Application Ref:	3/2025/0496			 Ribble Valley Borough Council www.ribblevalley.gov.uk				
Date Inspected:	02/09/25	Site Notice:	02/09/25					
Officer:	LW							
DELEGATED ITEM FILE REPORT:					APPROVAL

Development Description:	Demolition of rear lean-to extension and garage. Proposed single storey side and rear extensions to form garage, wc, utility and kitchen area.
Site Address/Location:	18 Hornby Road, Longridge, PR3 3RE.

DRAWING TITLE: PROPOSED SITE PLAN
DRAWING NUMBER: 0293 - 2000

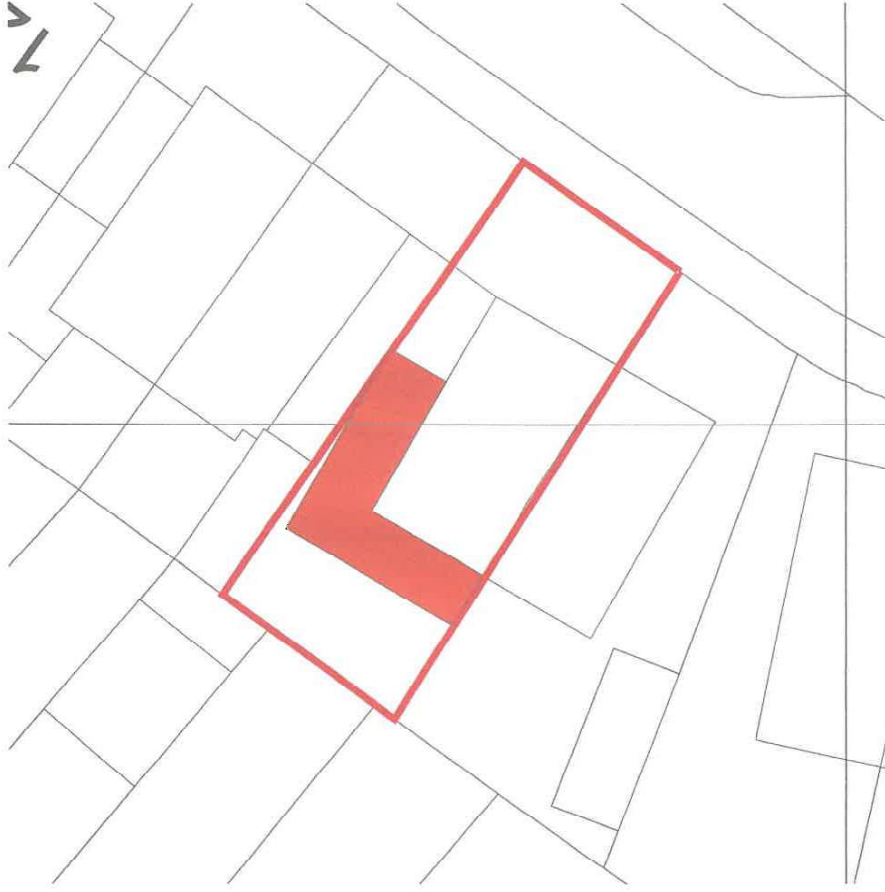
A consultation response from Lancashire County Council Highways was received 3rd October 2025 stating that the Local Highway Authority (LHA) does not consider that the application as submitted fully assesses the highway impact of the proposed development. A 2-bedroom dwelling should provide at least 2 off-street parking spaces, which are currently provided within the driveway and an additional existing garage. However, the proposal would result in the removal of off-street parking provisions at the side of the dwelling alongside the existing garage, with the proposed garage being smaller than the recommended minimum internal dimensions for vehicular parking. As such, the original scheme would result in just one off-street parking space being retained to the front of the property.

Following this, an amended Proposed Site Plan has been submitted which shows an extension of the existing driveway to allow for two off-street parking spaces. This has been subject to review by the LHA who raise no objection to the revised parking arrangements subject to the imposition of a condition. It is also noted that new driveway will require an extension to the existing vehicular crossing within the adopted highway which will need to be constructed under a Section 171 agreement with the LHA.
